Colby Company, LLC

LUTHER BONNEY ENERGY UPGRADES ADDENDUM #1 MARCH 15, 2012

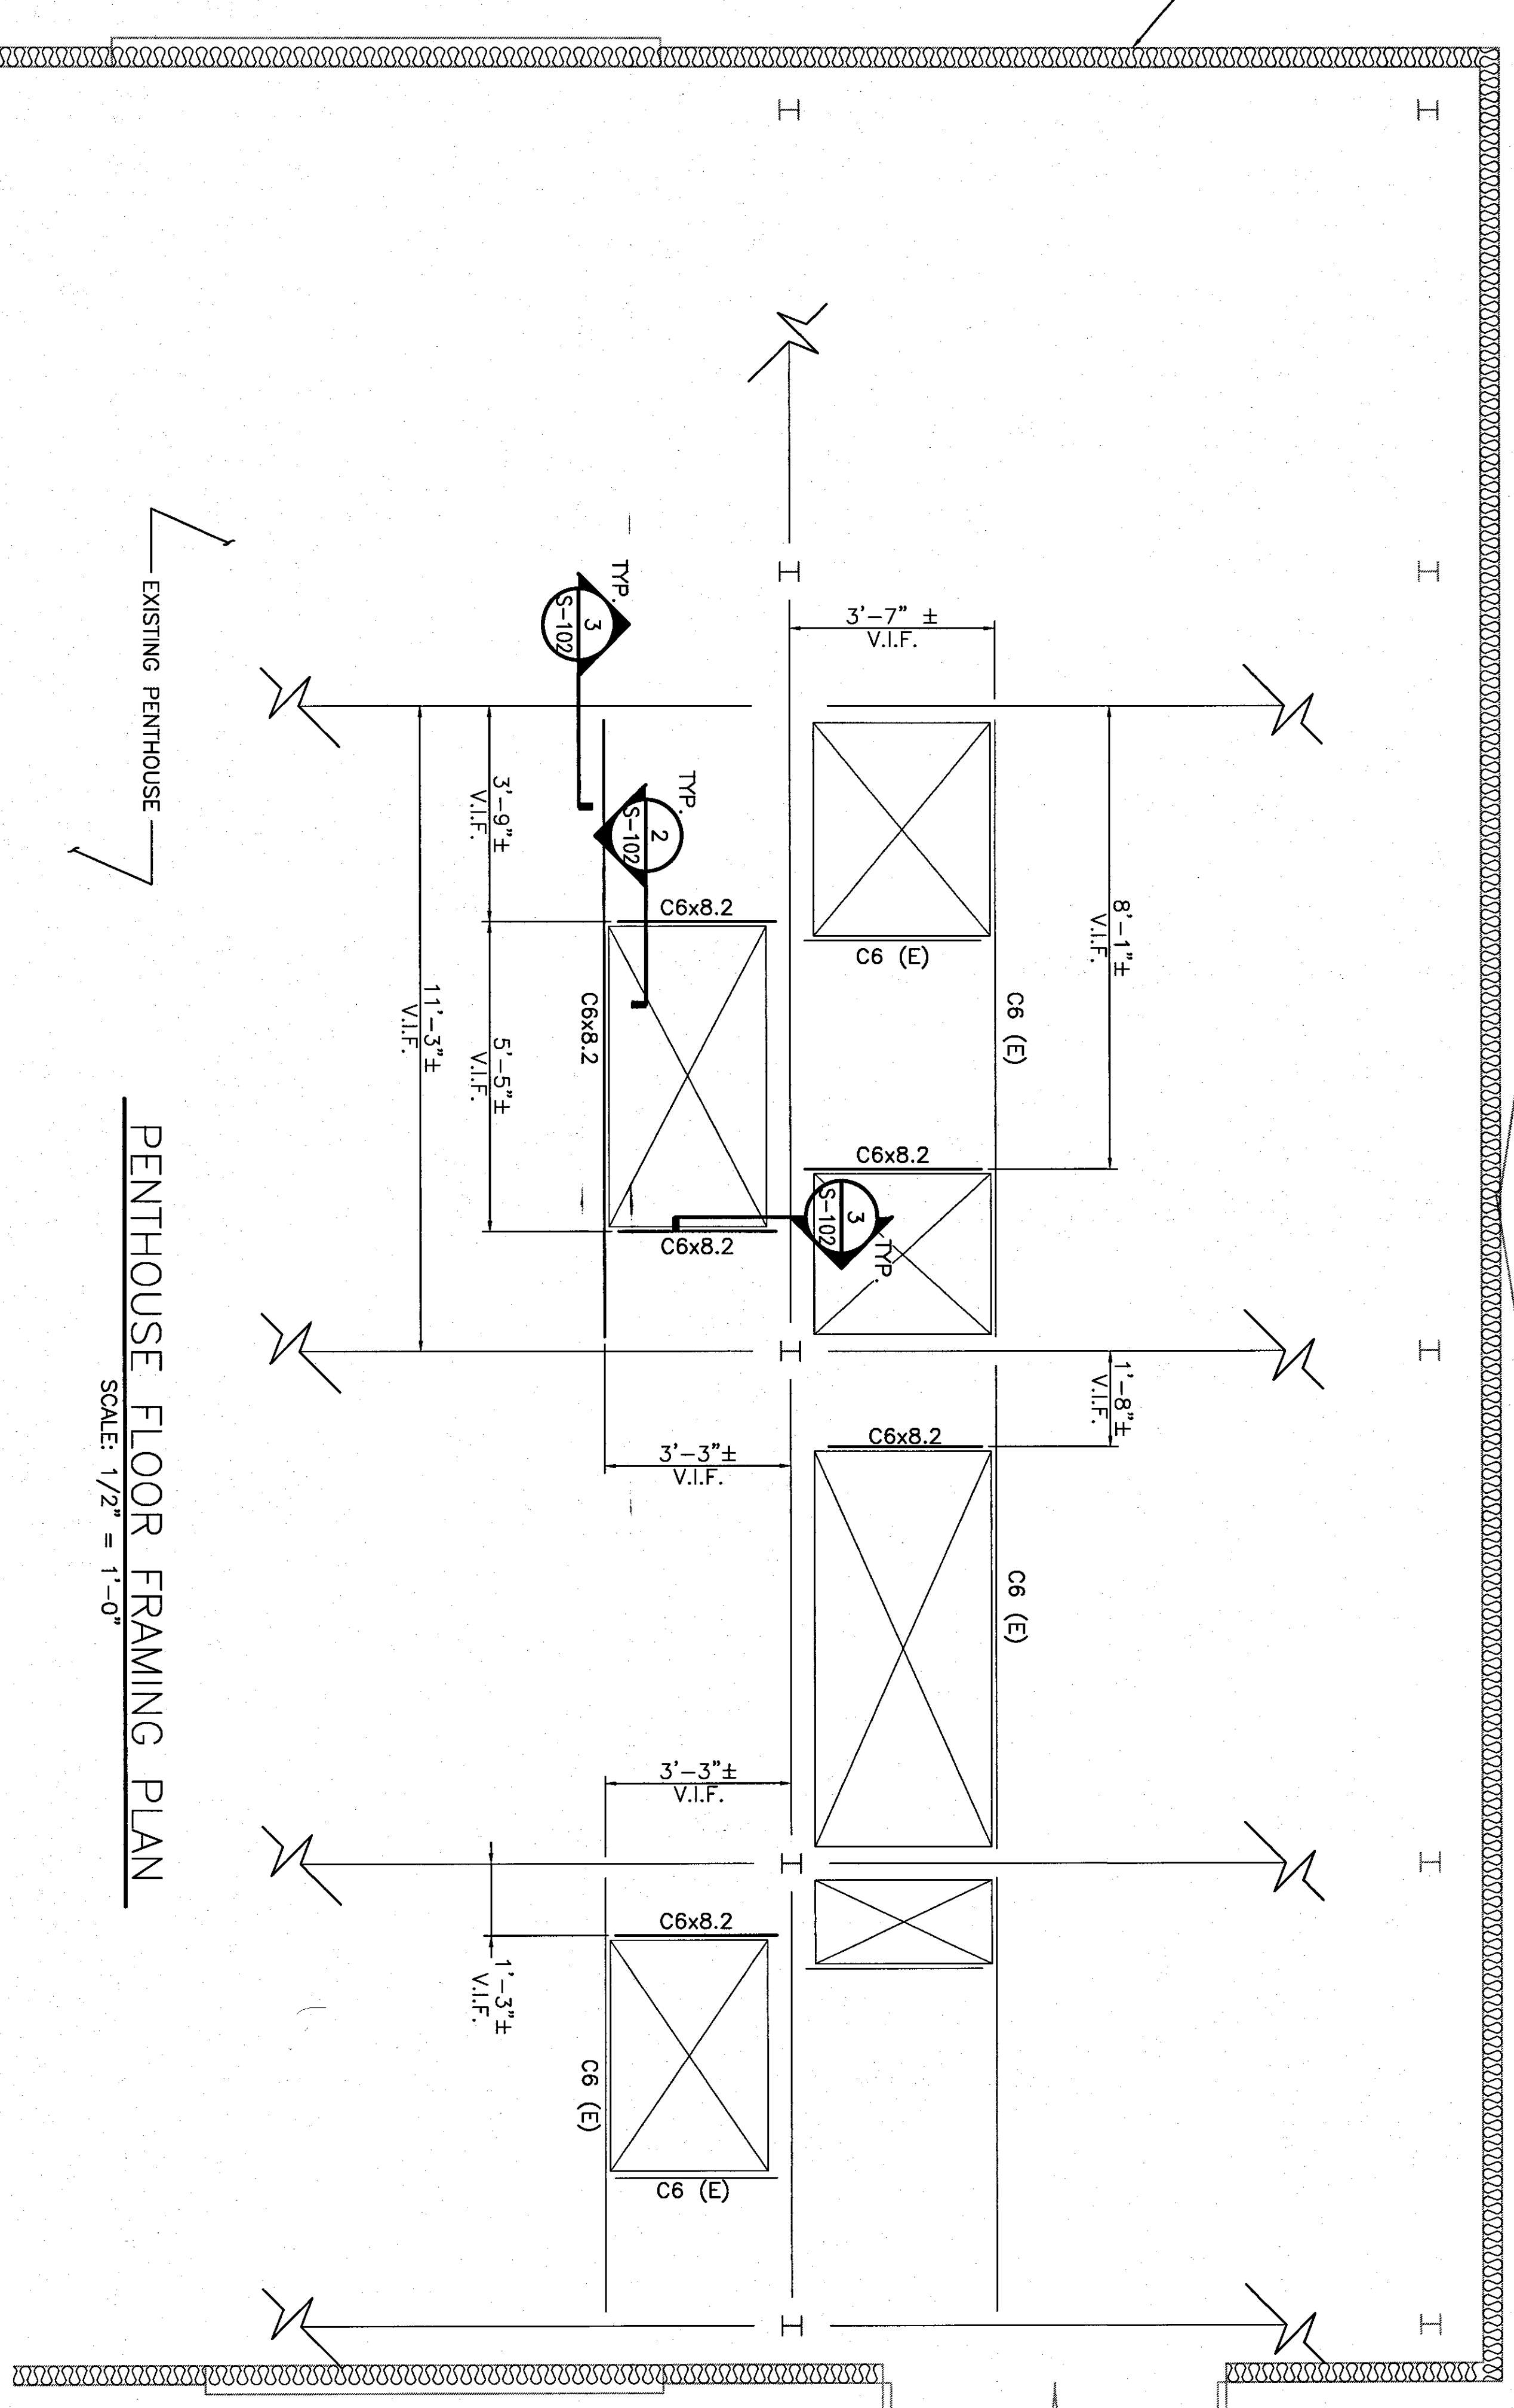
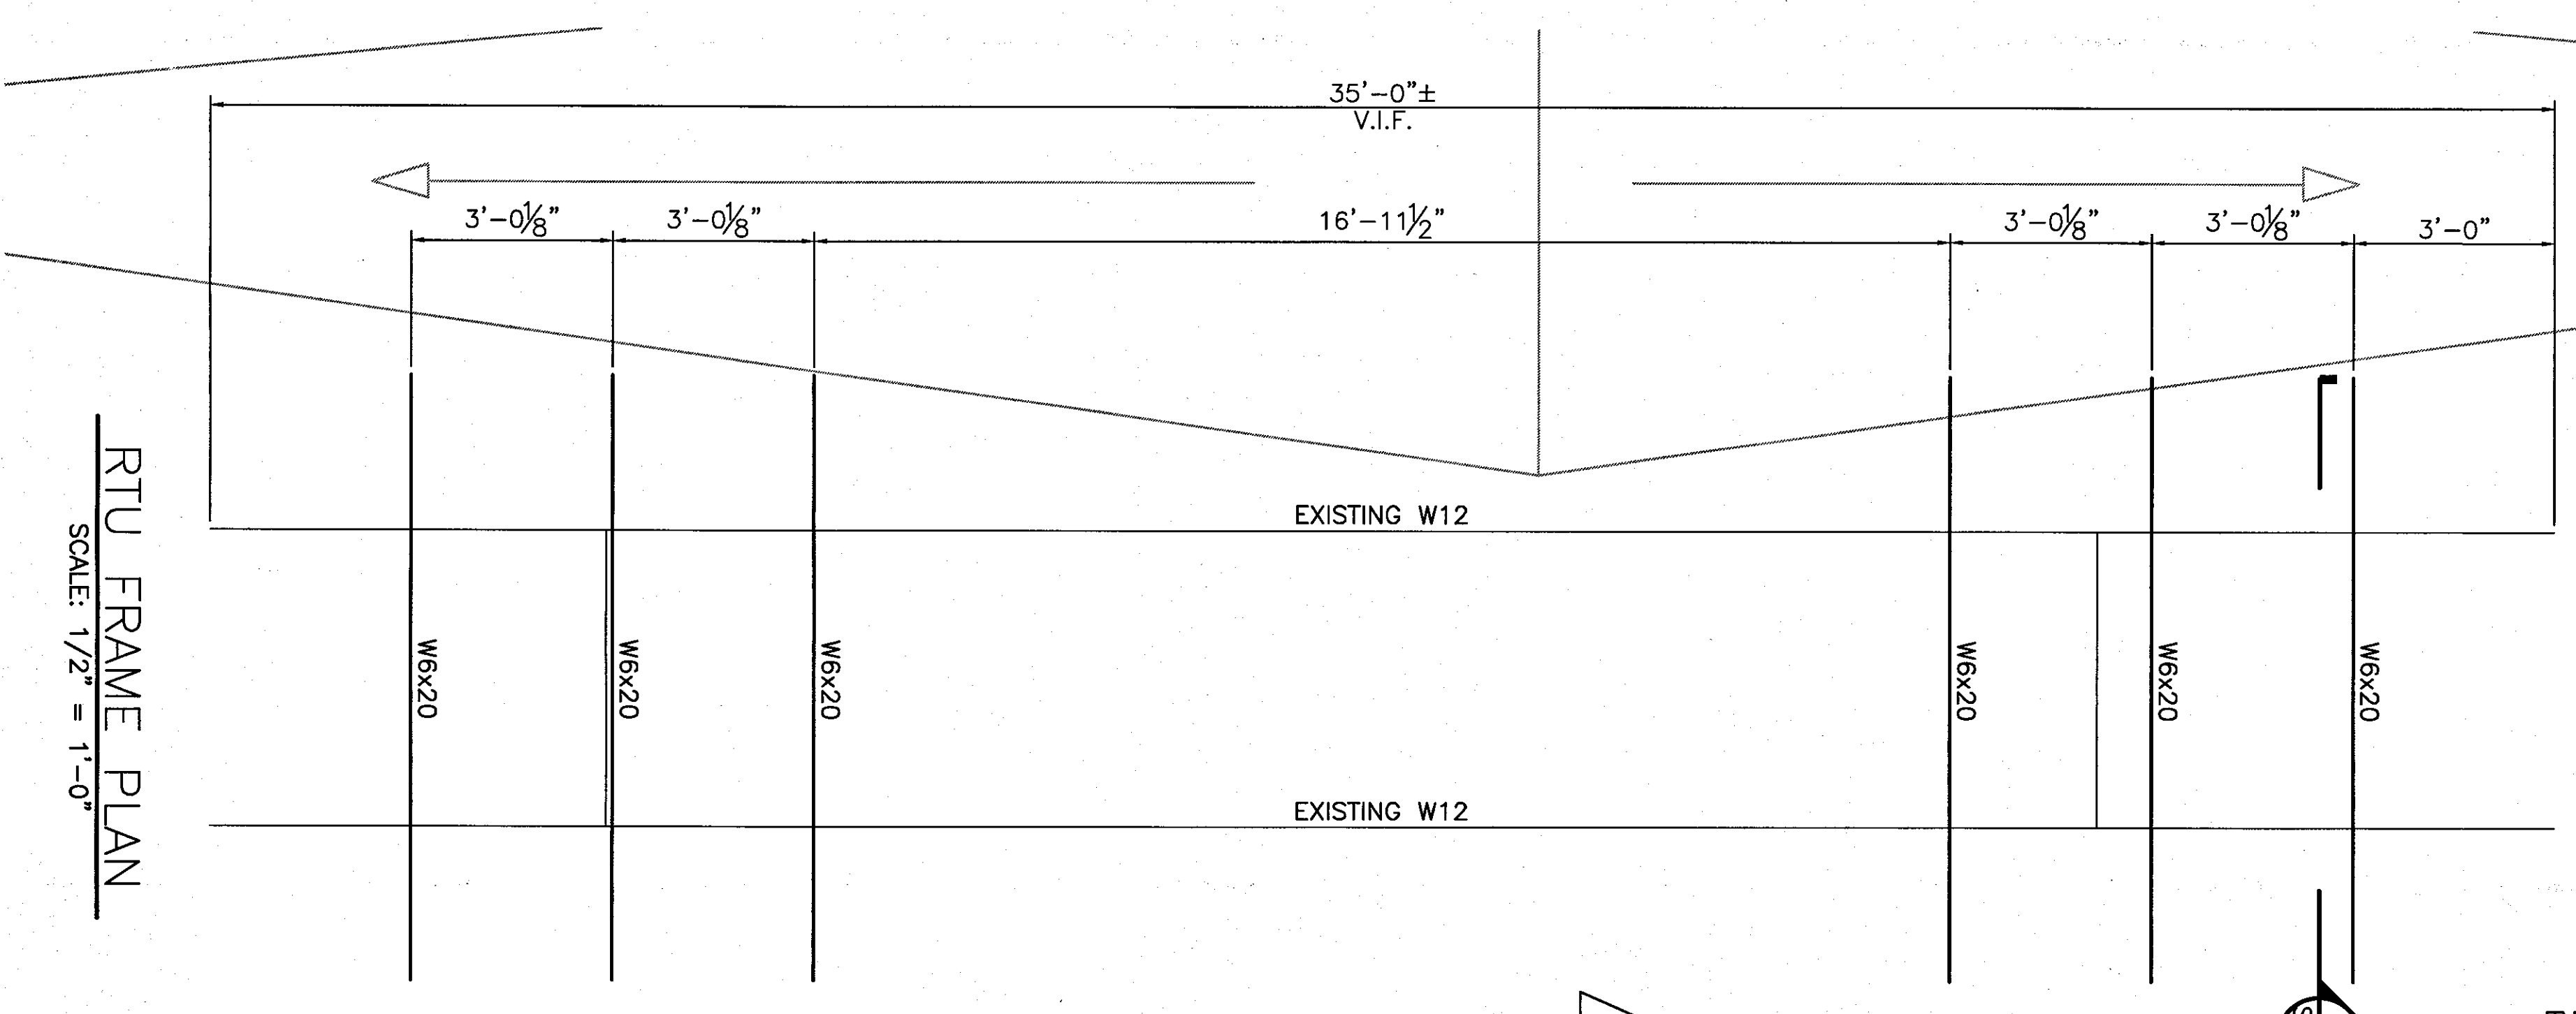
3. The structural drawings show new W6 x 20 support steel for the new condensing units. What is the requirement for the finish on these steel beams: prime painted, prime and two coats of finish, or hot dipped galvanized?
 - Shop prime painted and touch up paint for field welds.

SECOND FLOOR ELECTRICAL DEMOLITION PLAN
SCALE: 1/8" = 1'-0"

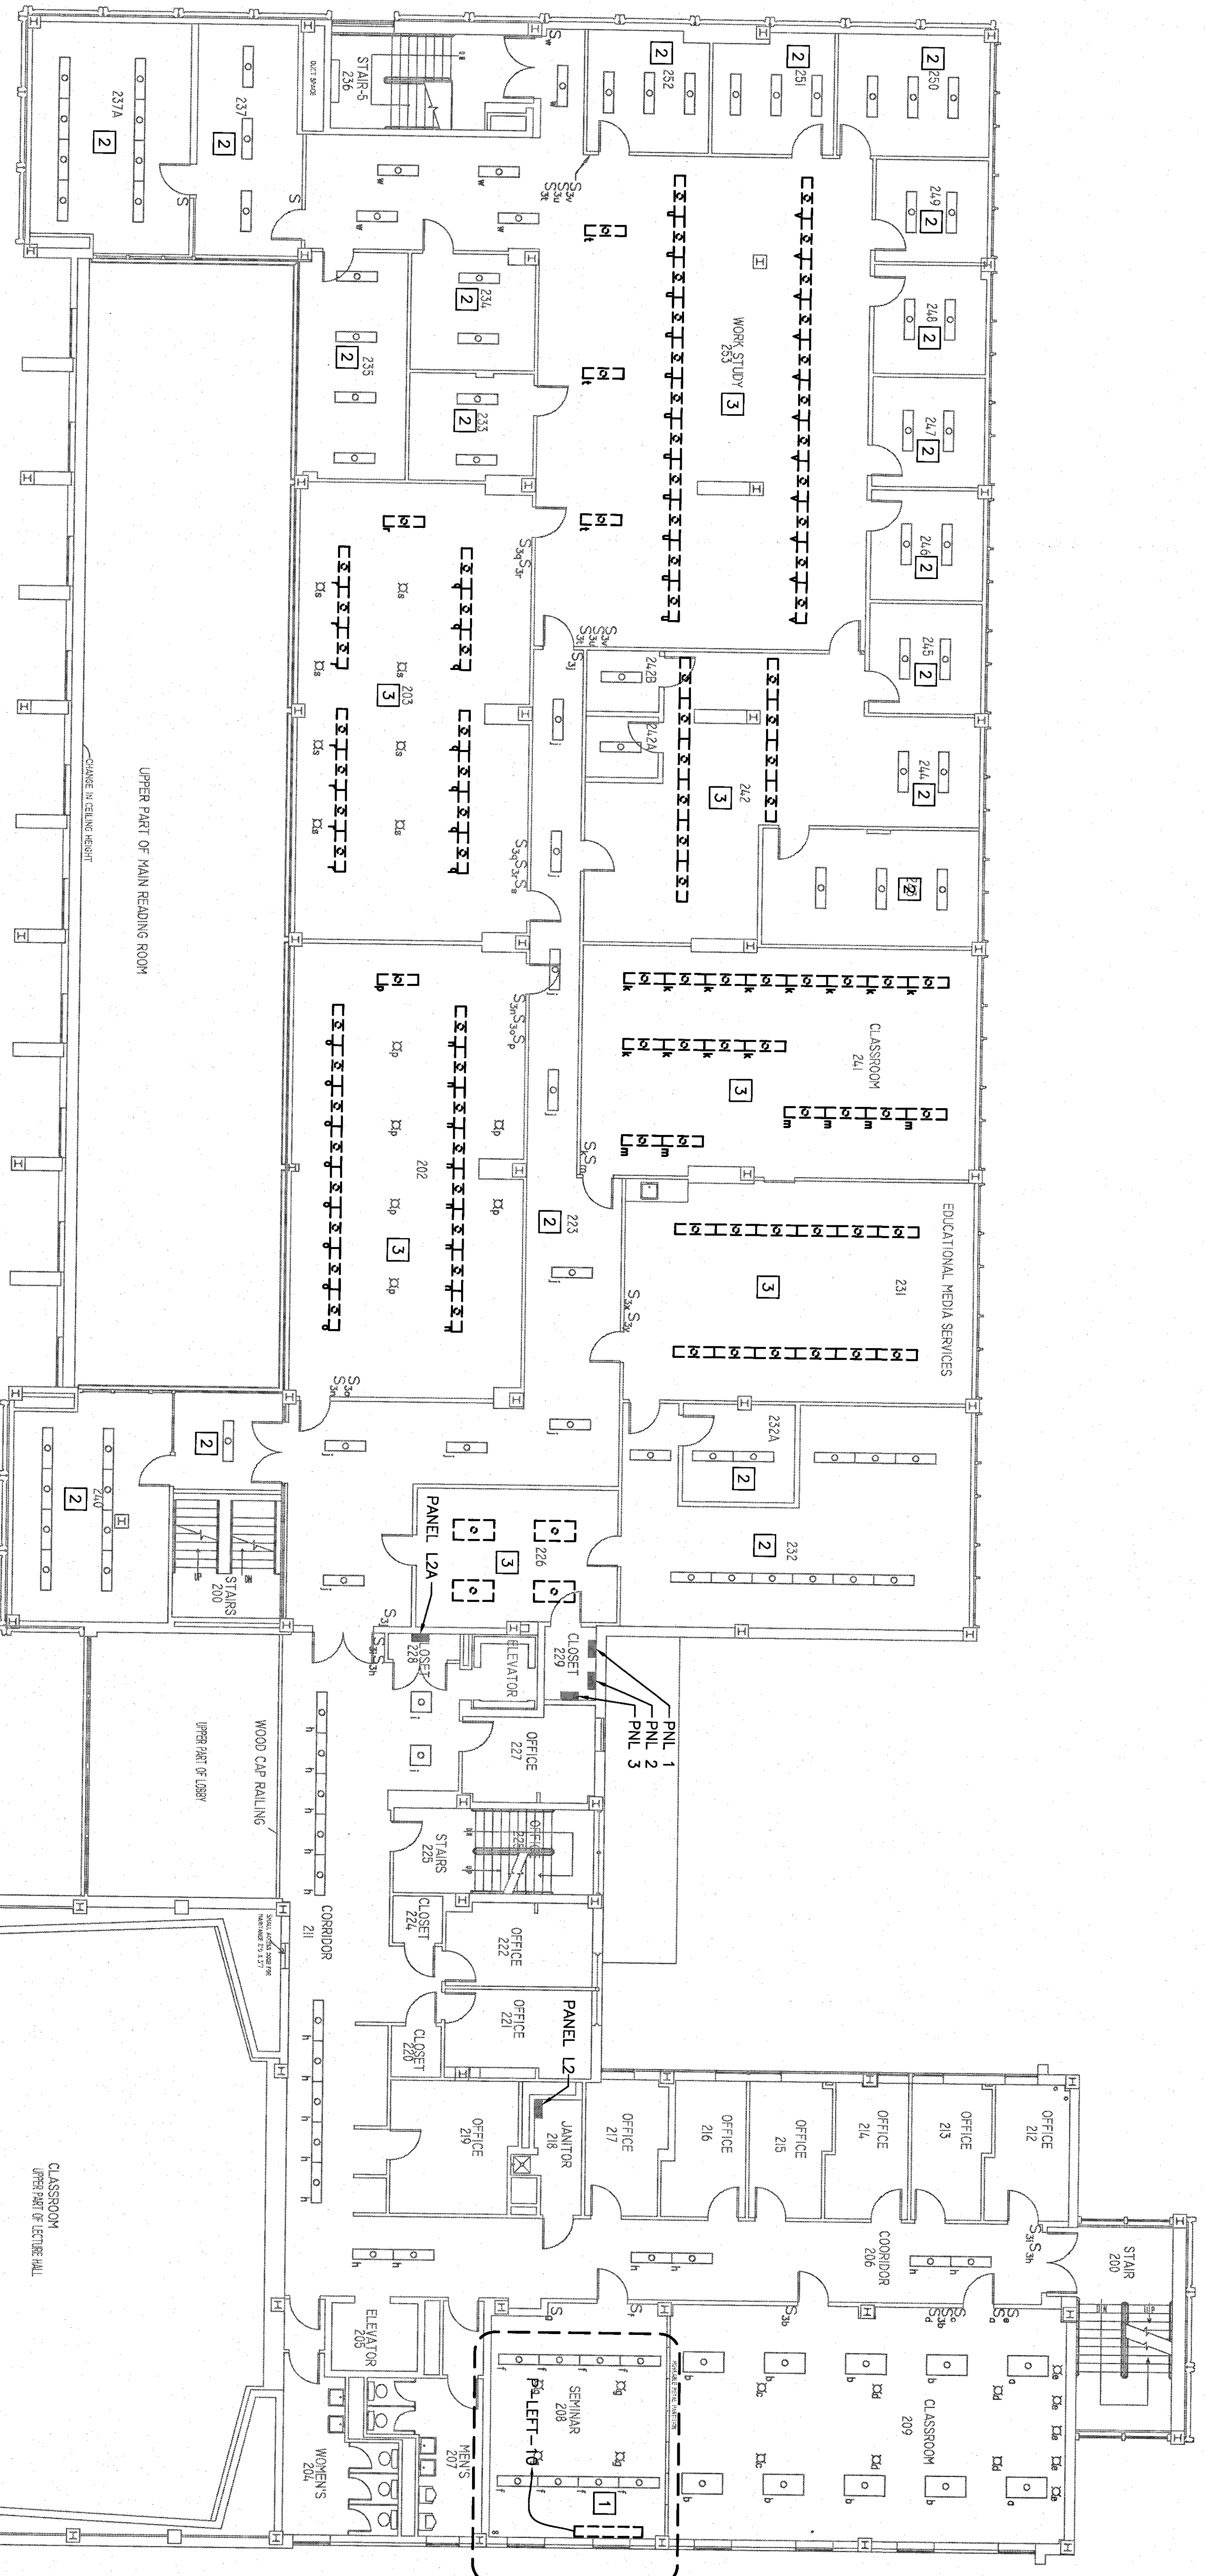
18. On the Electrical Demolition drawings the note "Disconnect and remove all associated electrical equipment, conduit, and wiring for unit ventilator." Is it the intent to remove all conduit and wire to the source or can the home run be salvaged for future connection to new equipment?

- Conduit home runs from the basement to the applicable floor can be salvaged if possible. All existing conductors to be removed and replaced with new.
